REQUEST FOR SEARS
DOOLEY'S LIDCOMBE CATHOLIC CLUB - SSD 7603
AUBURN COUNCIL COMMENTS

Thank you for the opportunity to comment on the draft SEARs for the Dooley's Lidcombe Catholic Club proposal SSD 7603. Council's comments are outlined below in the same structure as the Draft SEARs.

Hotel & Tourist Related Development – Dooleys Lidcombe Catholic Club (SSD 7603) Request for Secretary's Environmental Assessment Requirements

- 60m MAX. HEIGHT ZONE
- 18m MAX. HEIGHT ZONE
- 36m MAX. HEIGHT ZONE
- OVER THE HEIGHT LIMIT

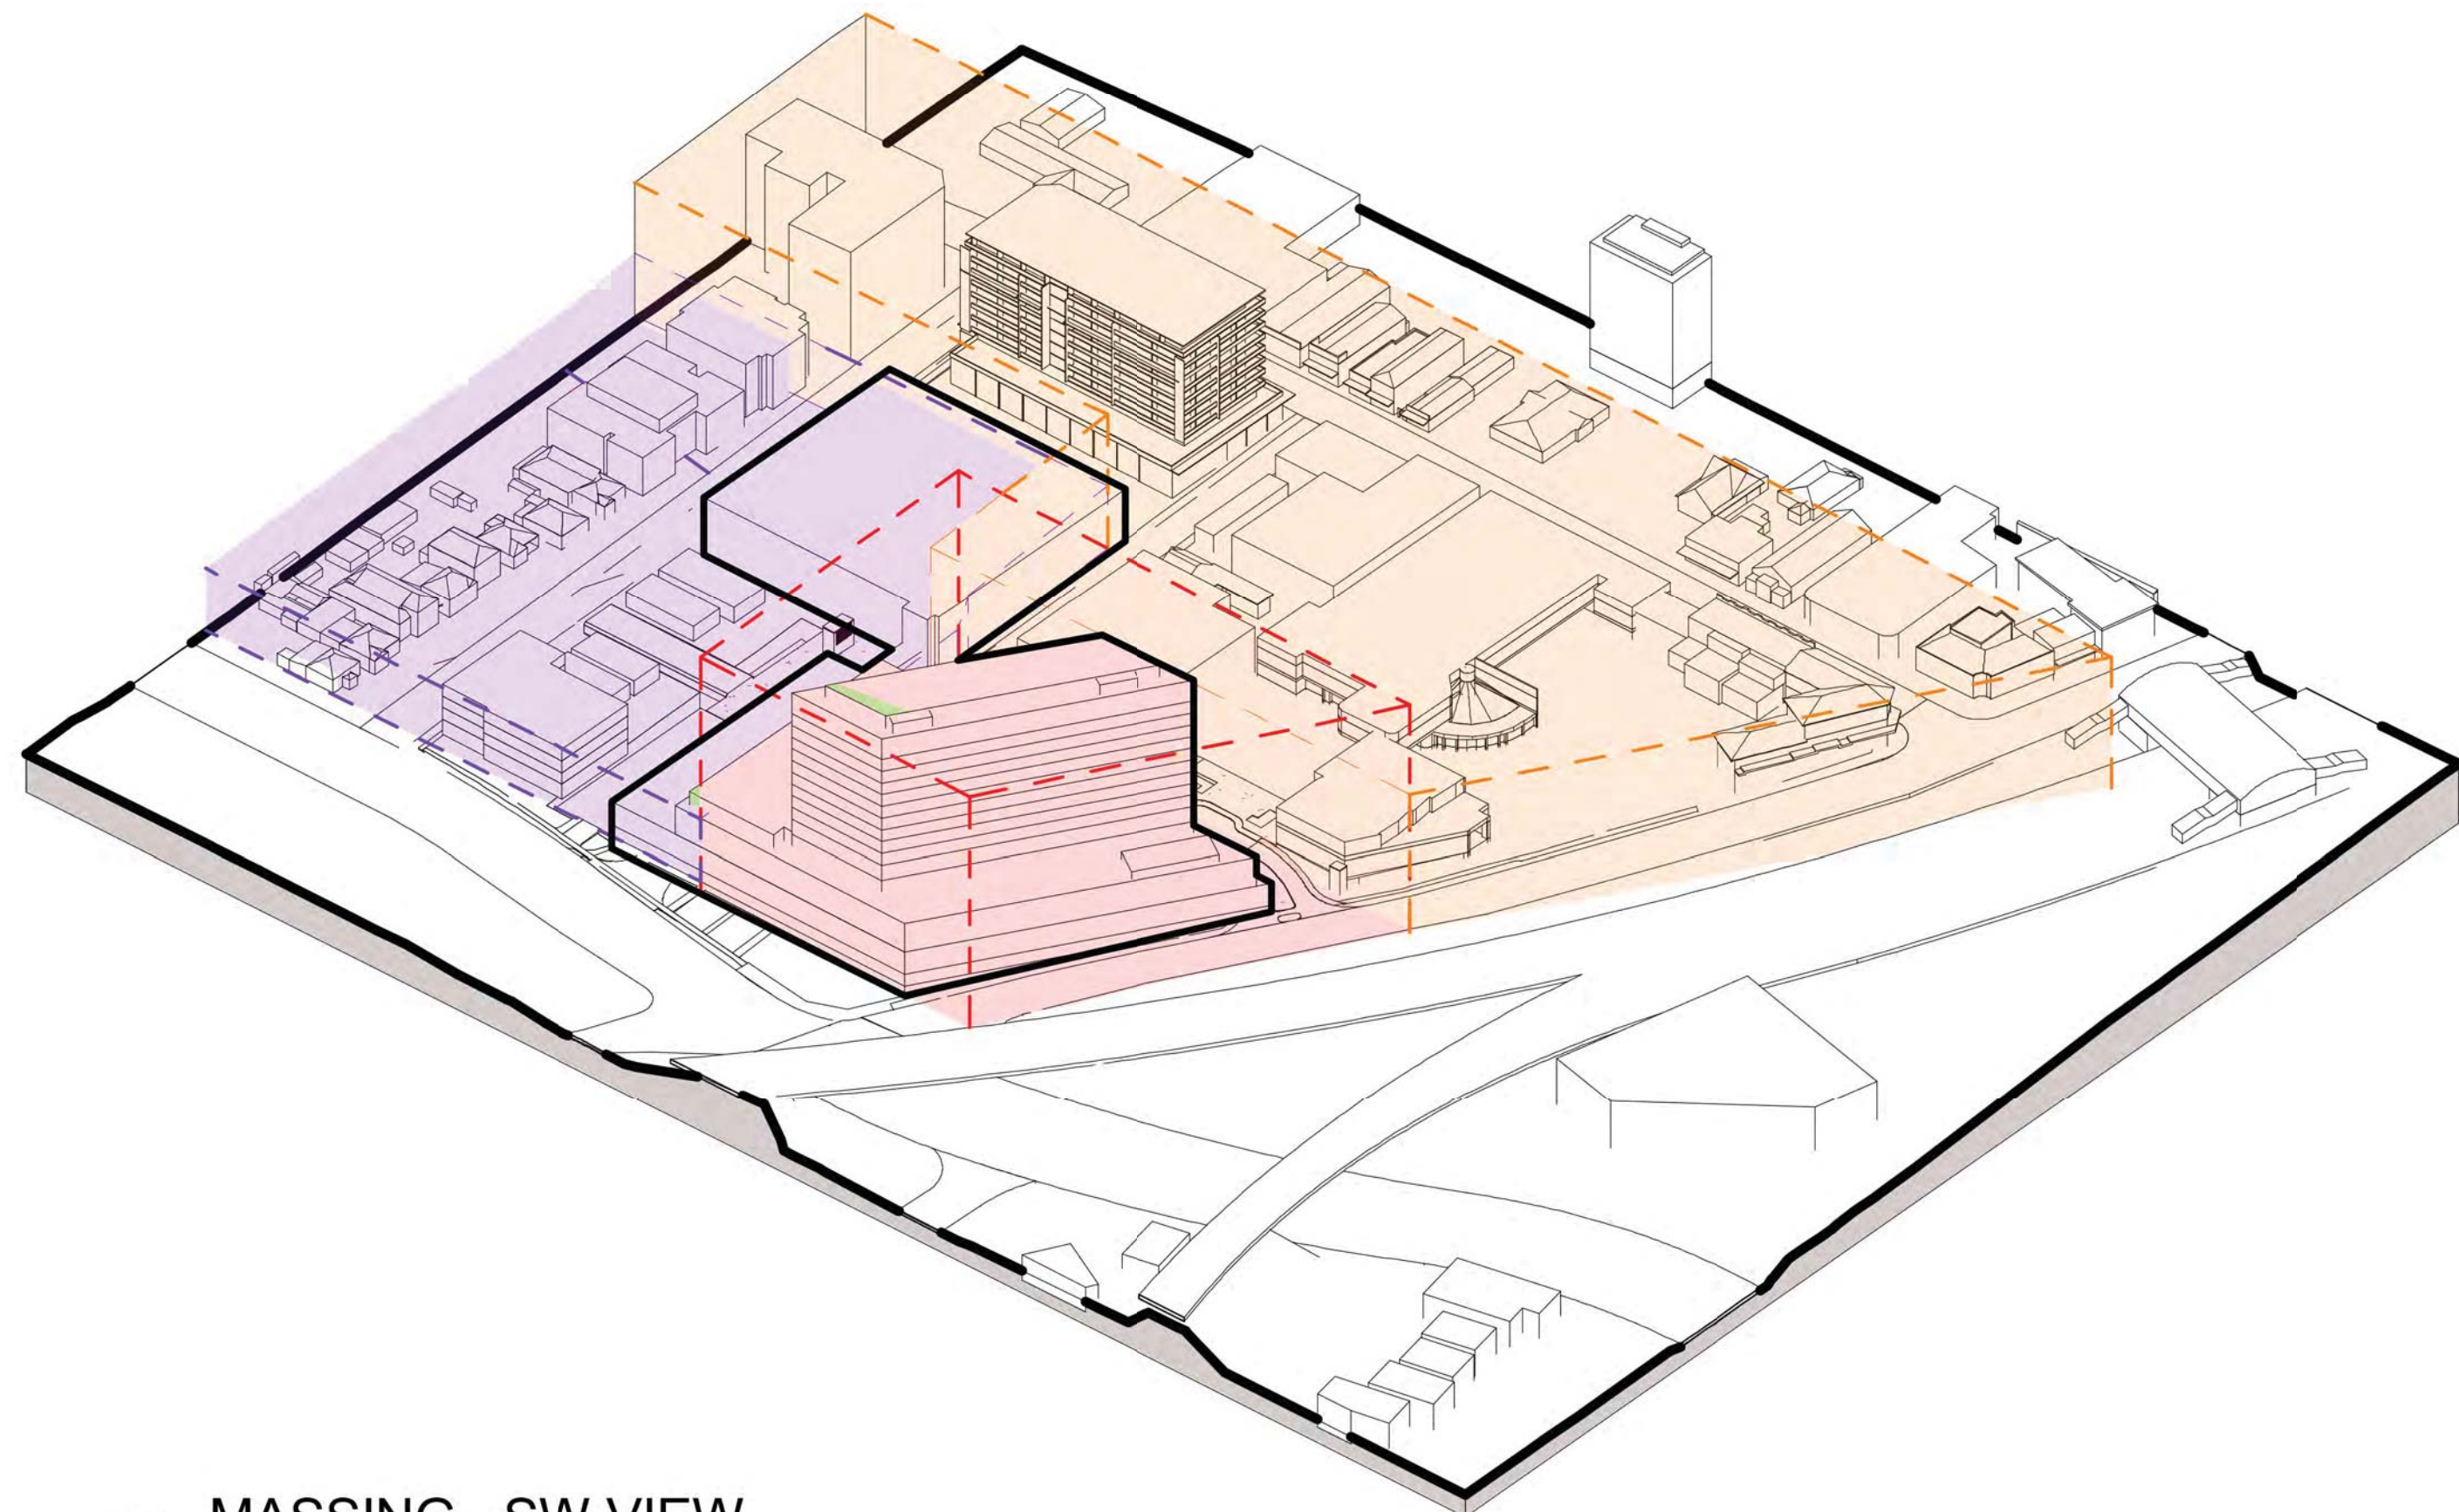
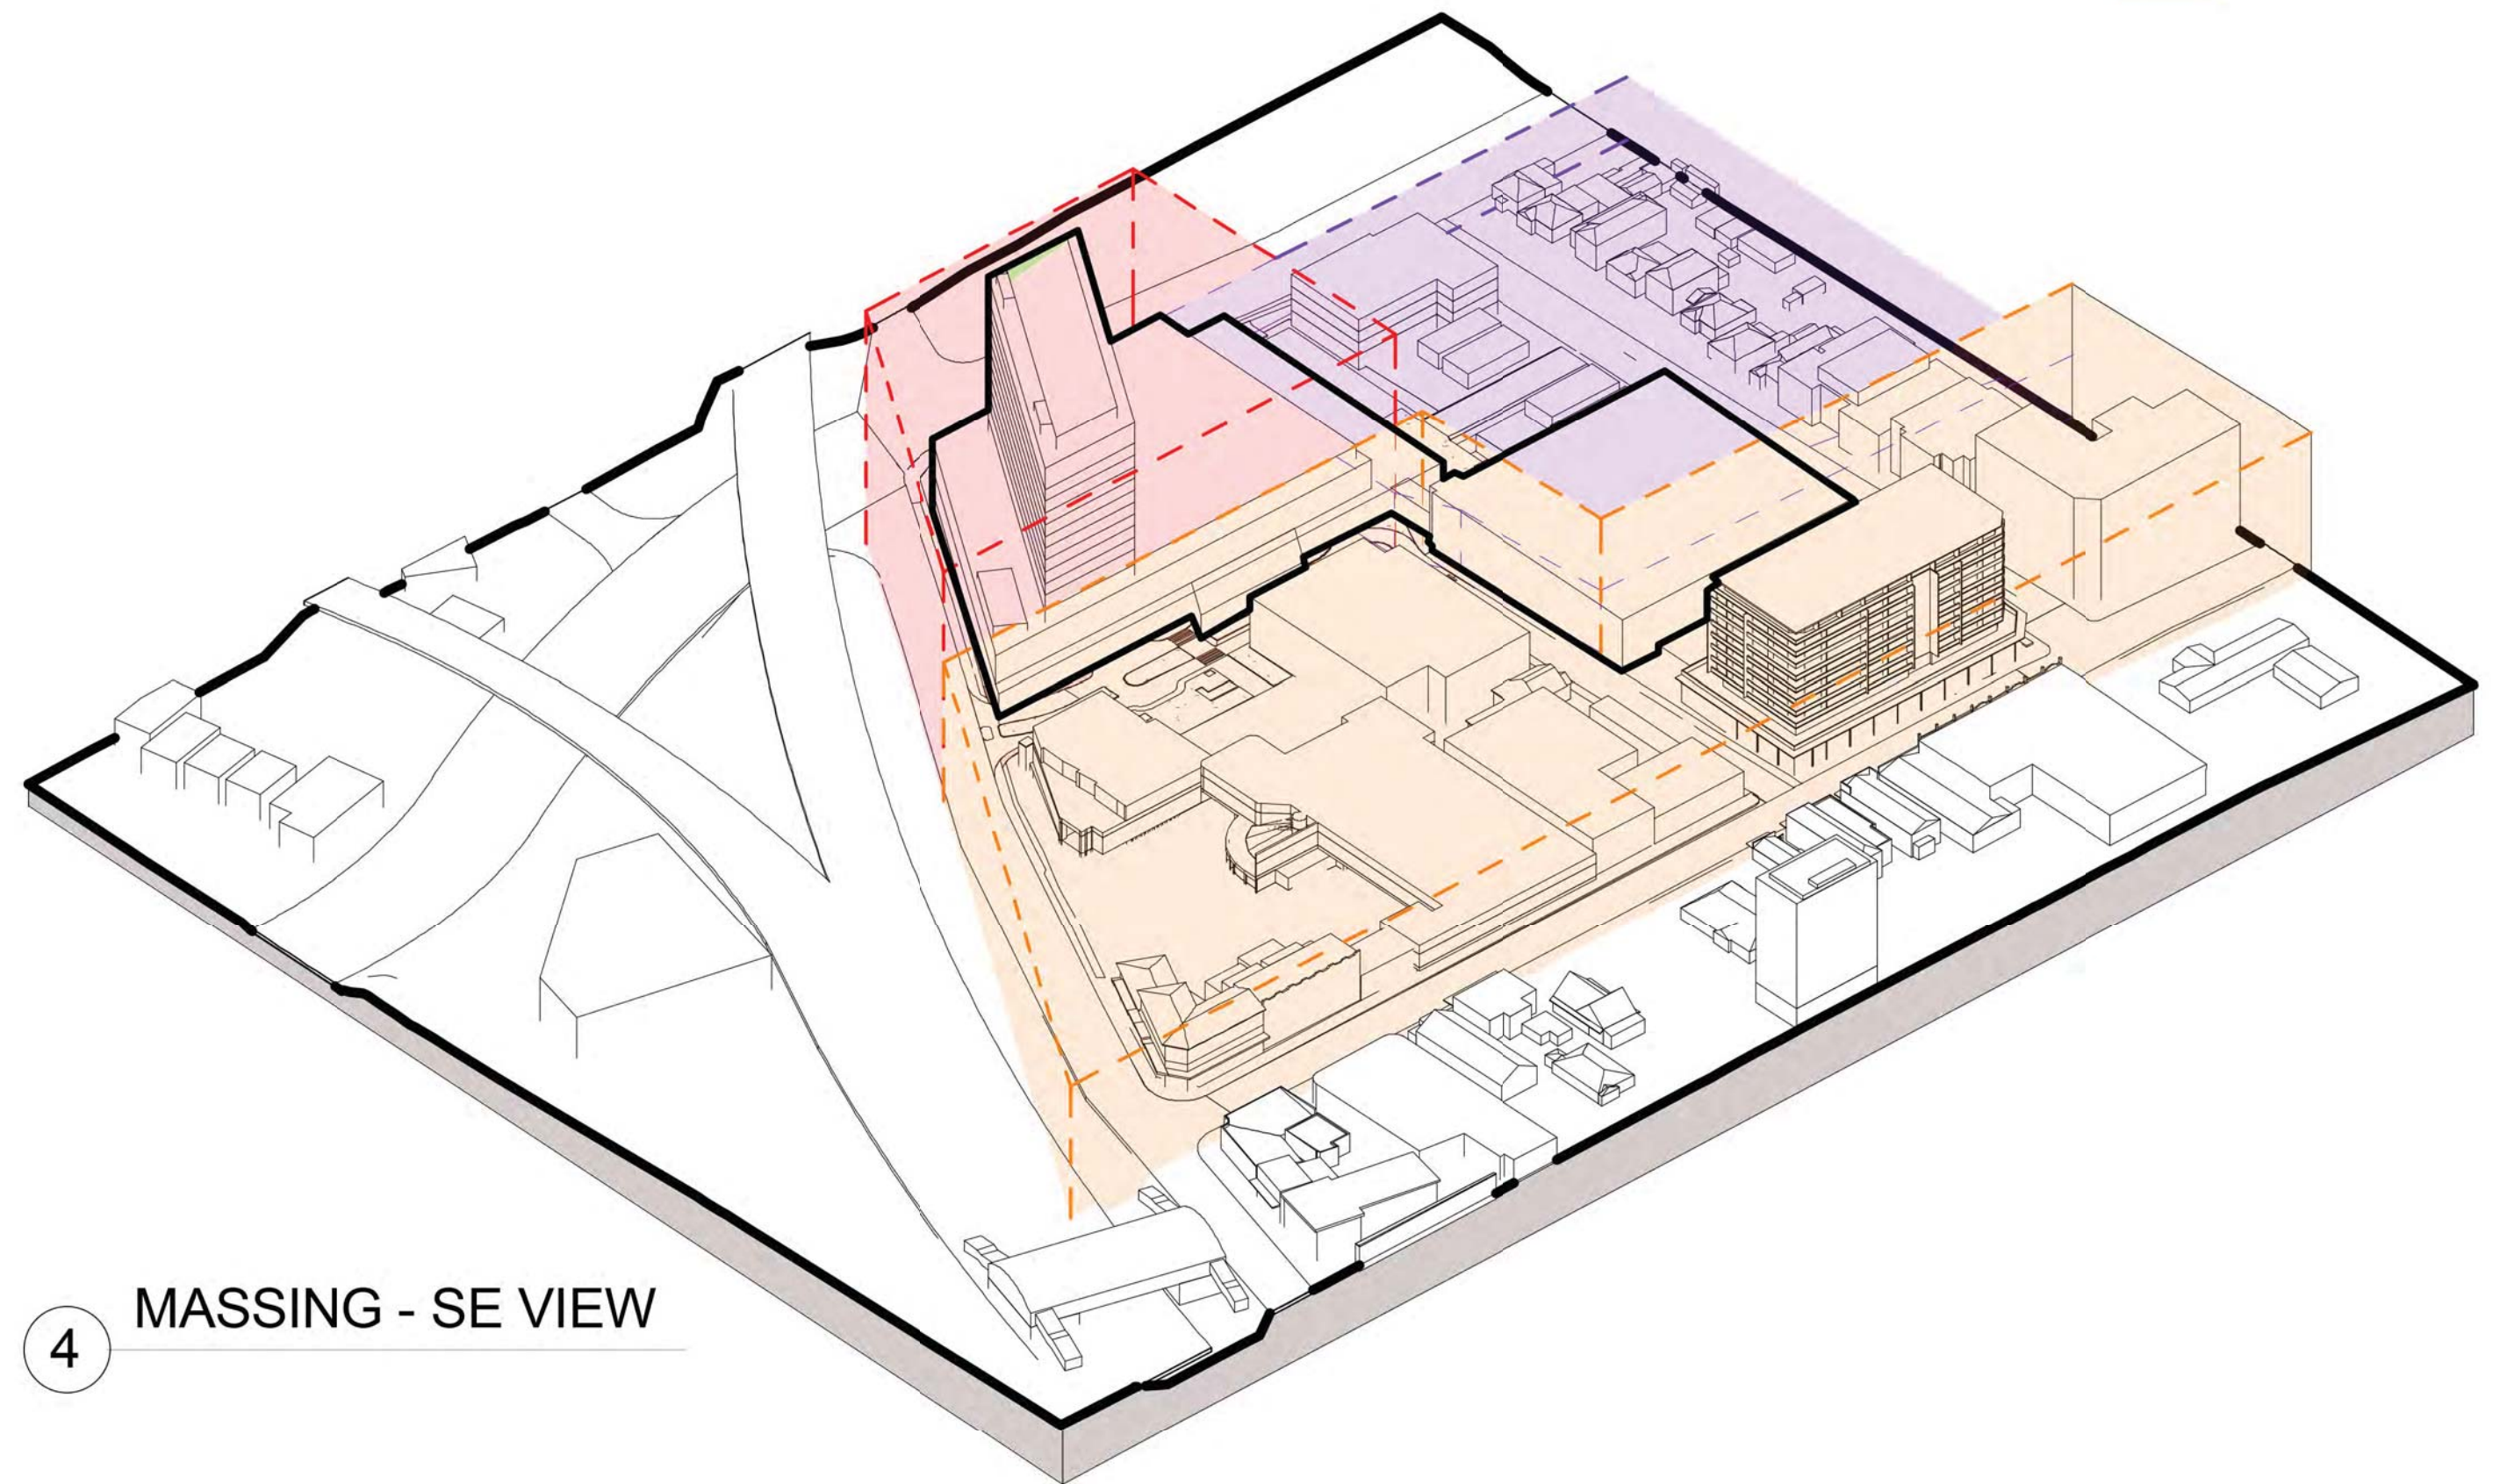
- Though it is not possible to determine the actual length of the hotel tower, it appears very long. Consideration should be given to breaking it up to reduce the apparent bulk and scale.
- All non-compliances with height and FSR should be adequately justified. The stated FSR seems very low for a proposal that includes a 60m high building. FSR calculations need to be shown.
- Further consideration as to the floor space ratio and determination of “site area” applying to the R4 zoned portion of the land is required. Clause 4.5(4) nominates that land on which the proposed development is prohibited is to be excluded from site area. This may have ramifications in terms of determining an overall FSR for the proposal.
- Note that any parking above the requirements contributes to the FSR (see definition of FSR in Standard Instrument).

1 CARPARK SECTION - NORTH / SOUTH
1 : 100

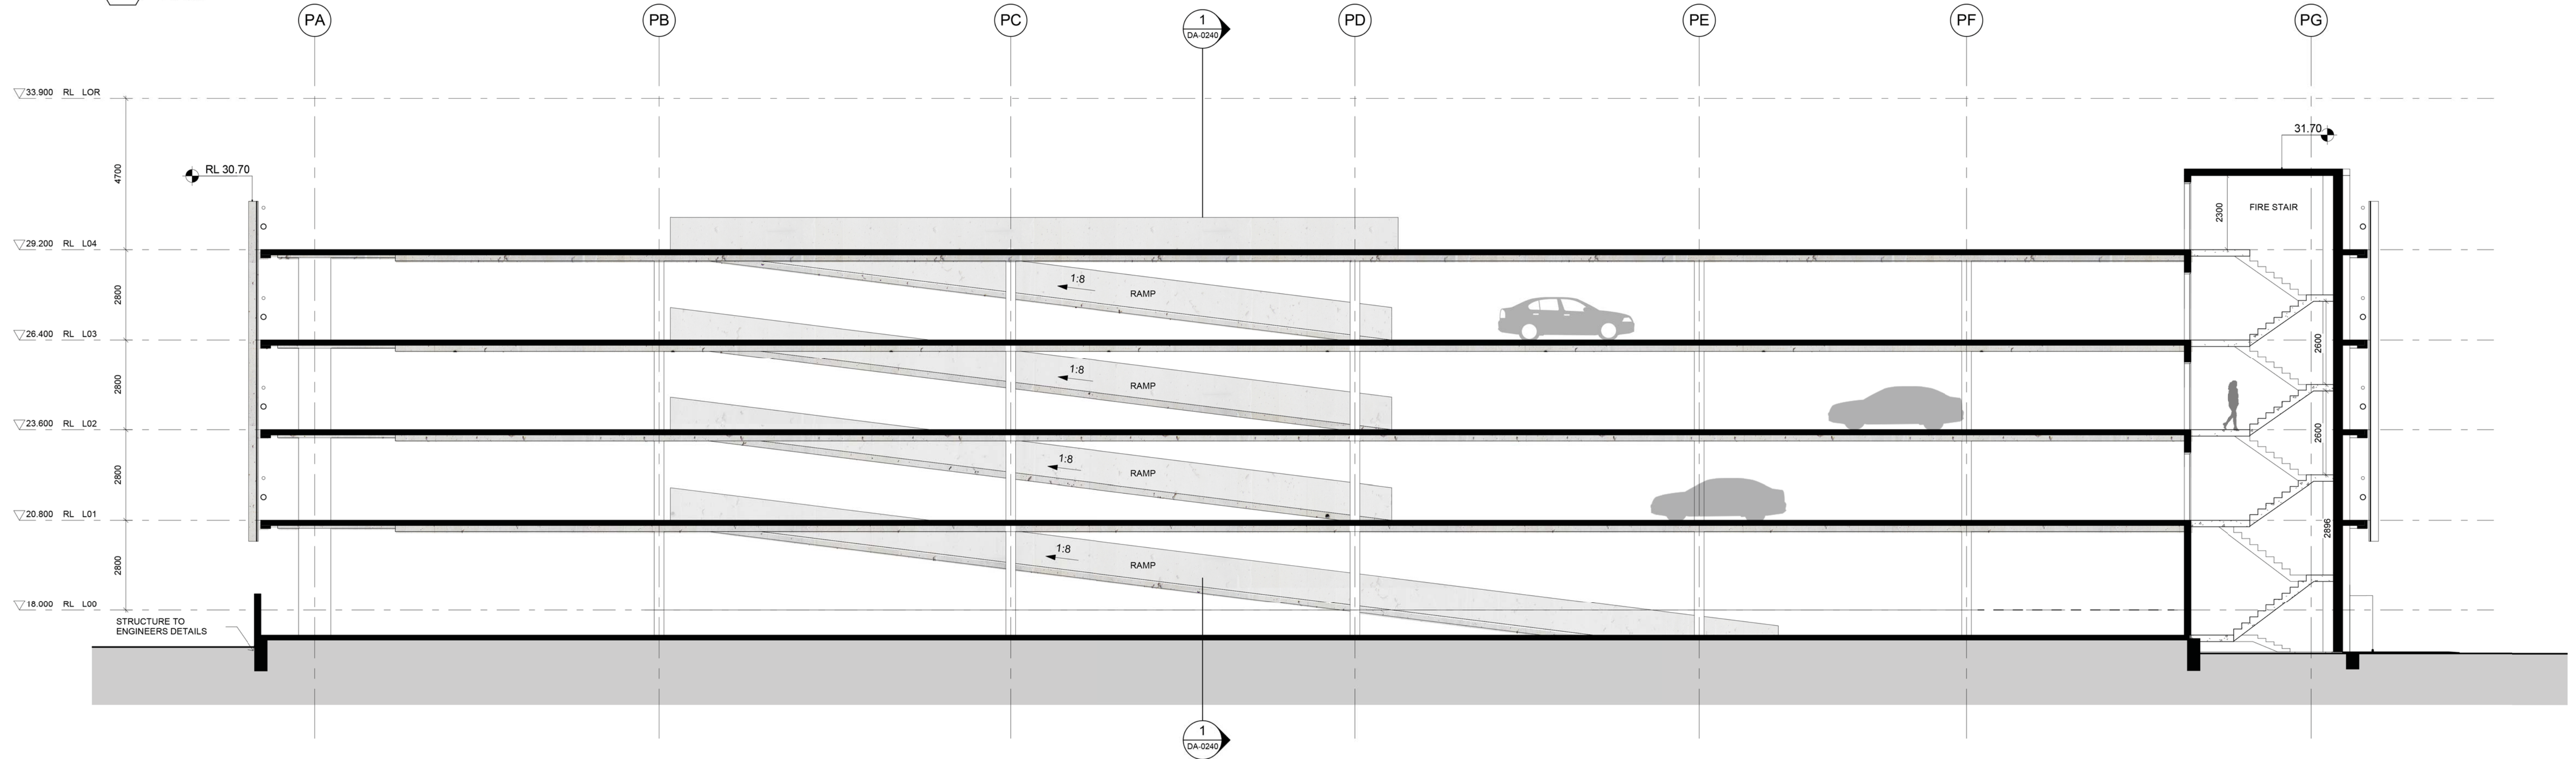
In relation to the multi-storey car park, it is recommended that the EIS:

- Outline alternatives considered to providing the required parking (eg part basement parking)
- Outline measures to provide for adaptability, particularly of the ground and first floor levels, to enable alternative future employment uses of these levels.

- Assess the setbacks, landscaping and design measures required to reduce the visual impacts, the perceived bulk of the structure and to ensure adequate solar access to existing and future residential development.

- Whether the car park can be sleeved in active (eg retail) uses along Board St to support a vibrant active Lidcombe centre.
